SSD 6013. Mixed use commercial office building and public car park within the North West Plot

Submission by:

Alan Sauran and Suzanne Aubrun

21 July 2013

21st June, 1pm

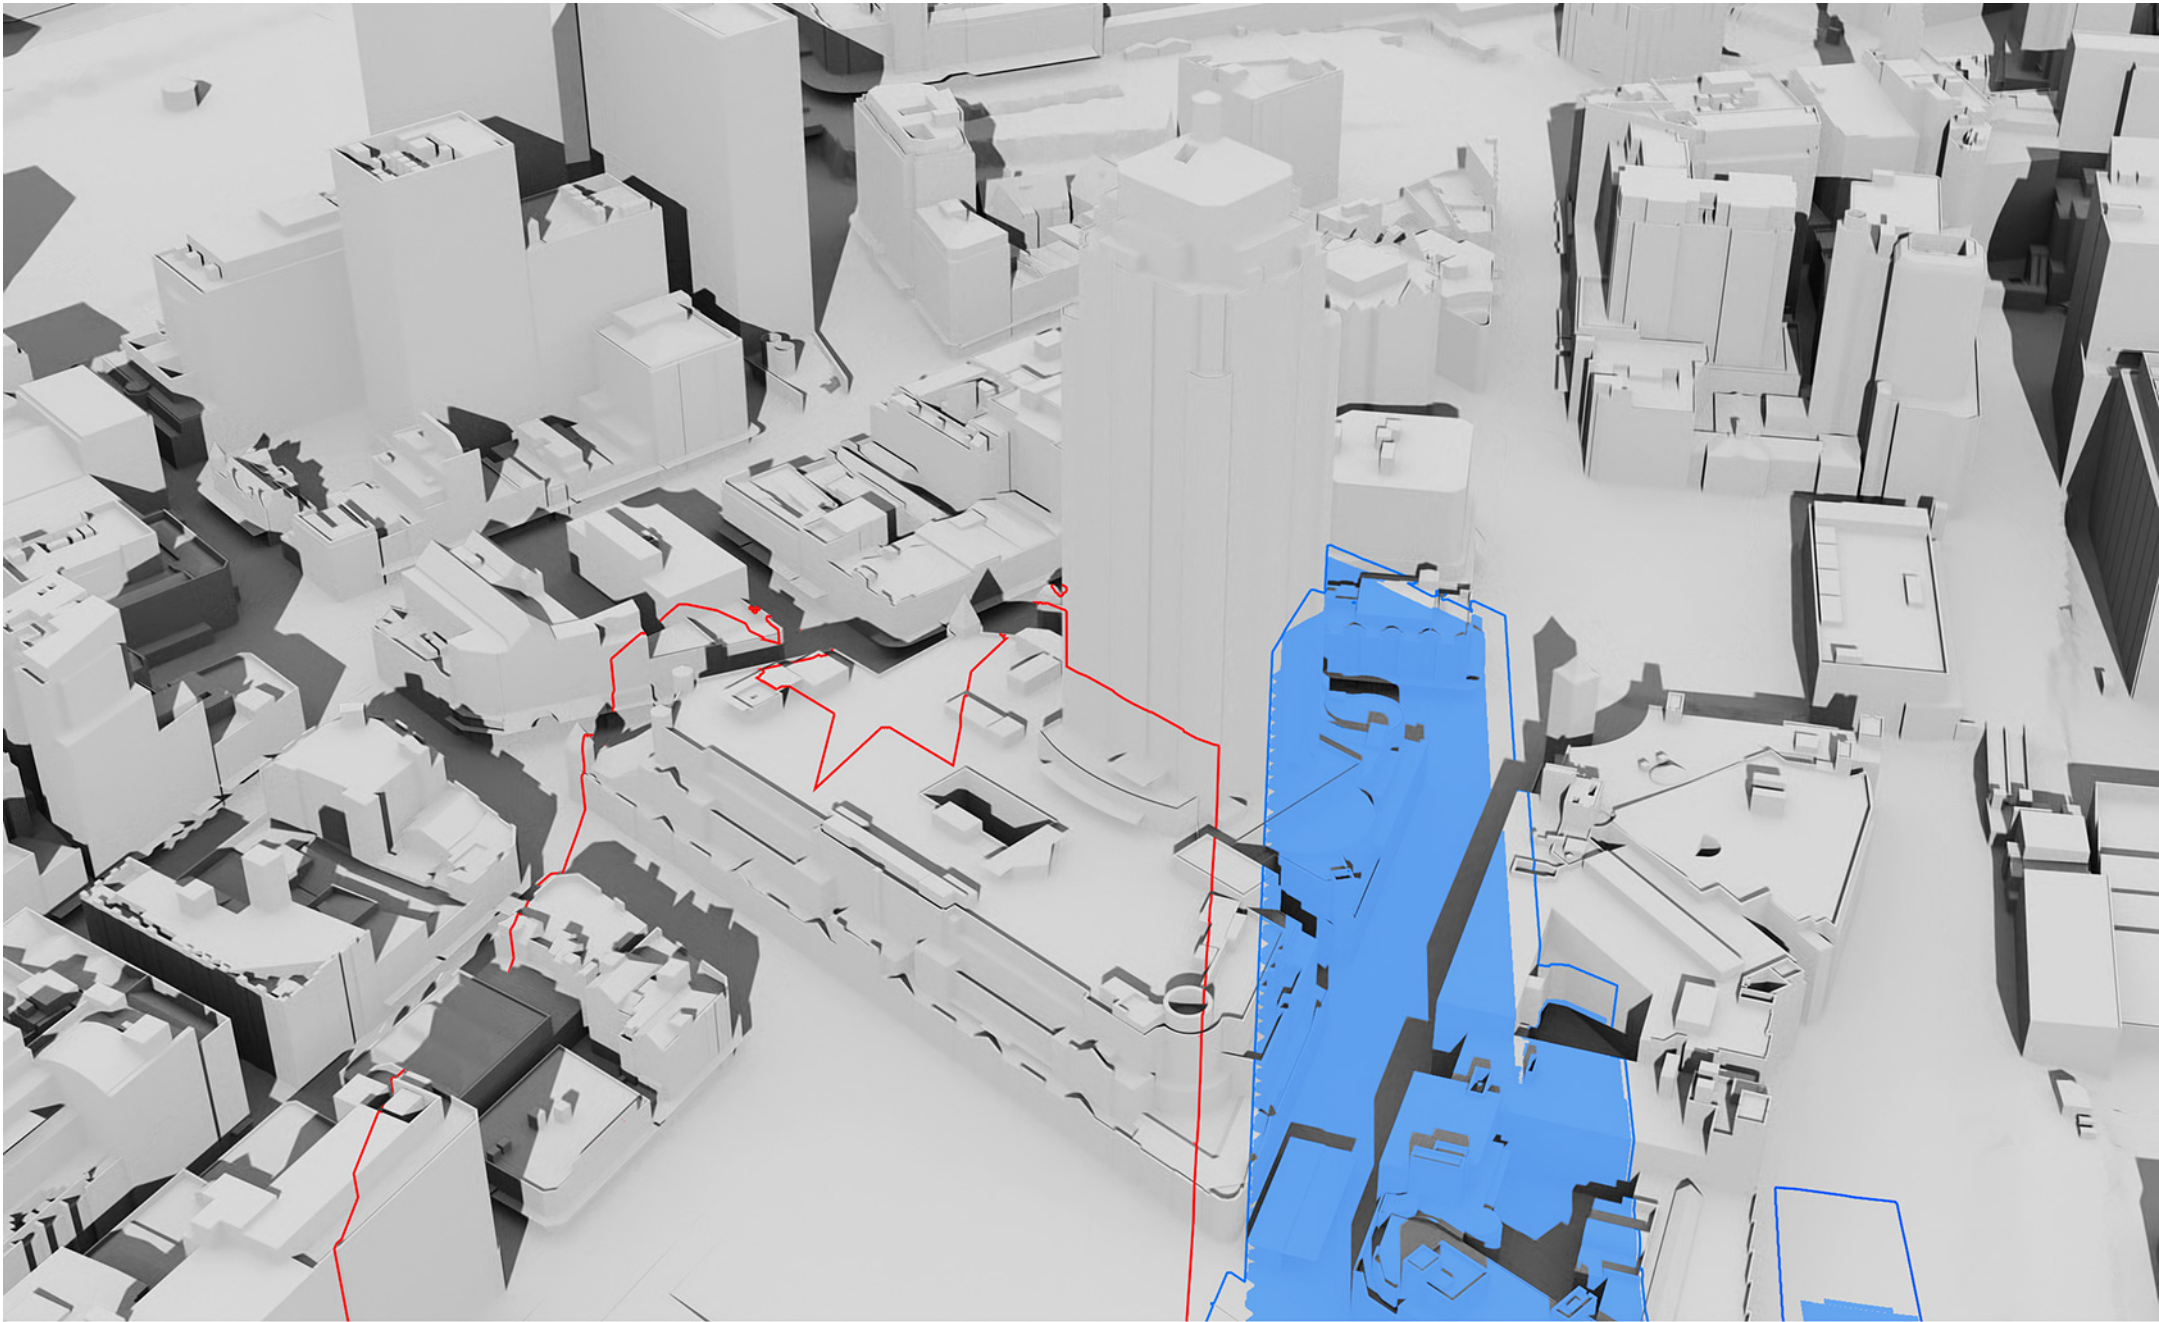
At 1pm the existing shadowing has been substantially, although not entirely, removed. However, overshadowing of lower levels of the west façade by the concept proposal parameter plan shadows for the N,NE and SE plots has already started.

21st June, 2pm

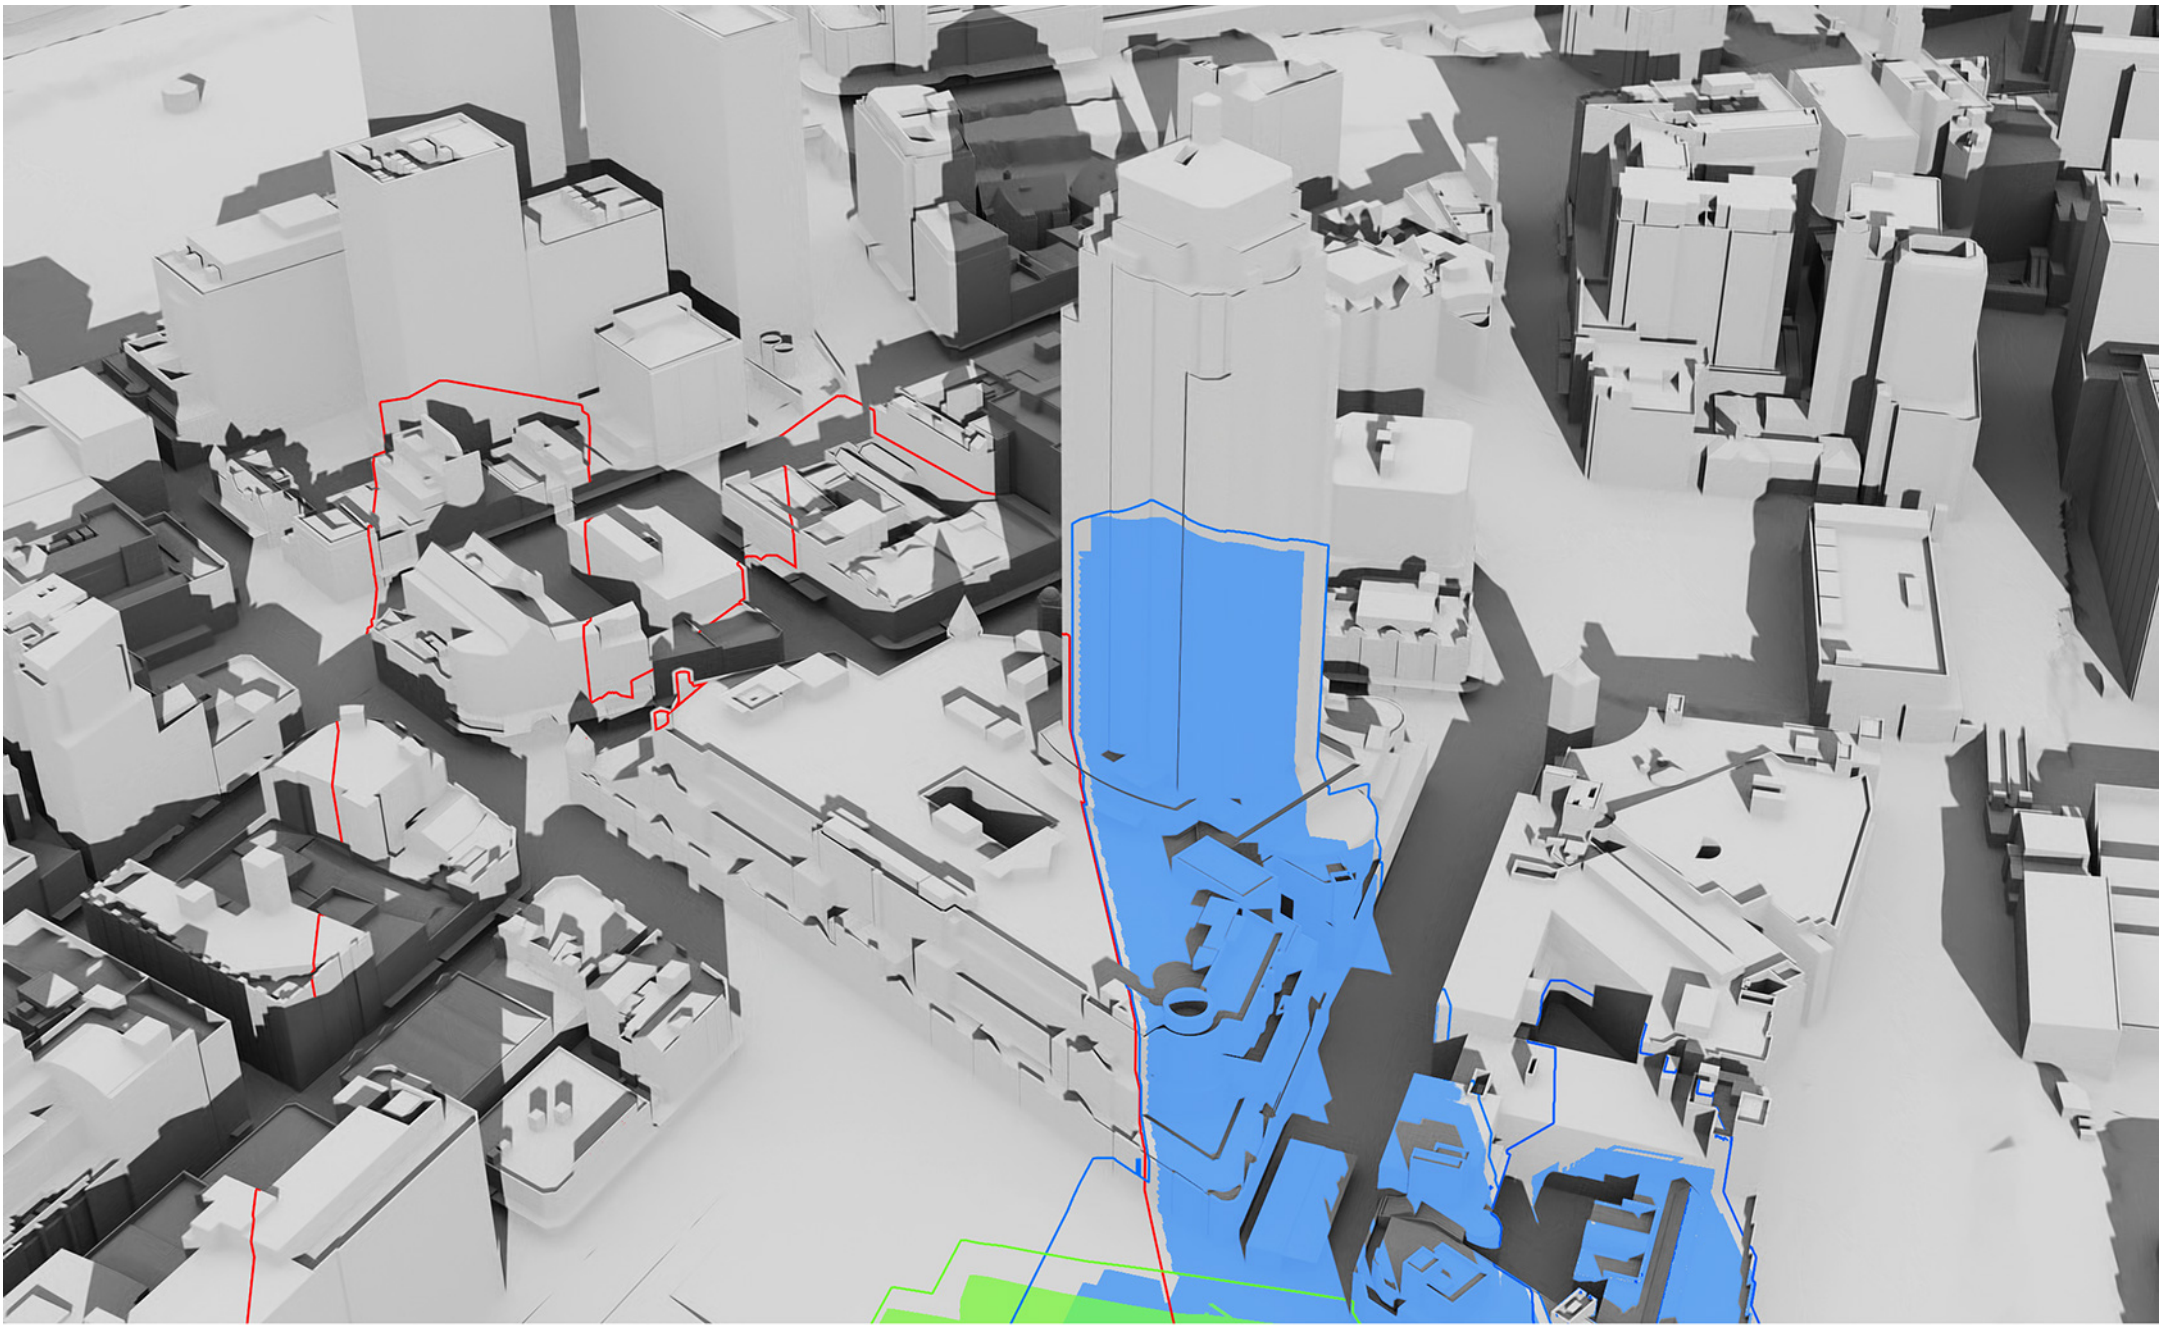
By 2pm the existing shadowing has been totally removed. However, overshadowing of the west façade by the SSDA4 and SSDA5 buildings has appeared and risen further up the west façade than the concept proposal parameter plan shadows for the N,NE and SE plots, which is still present.
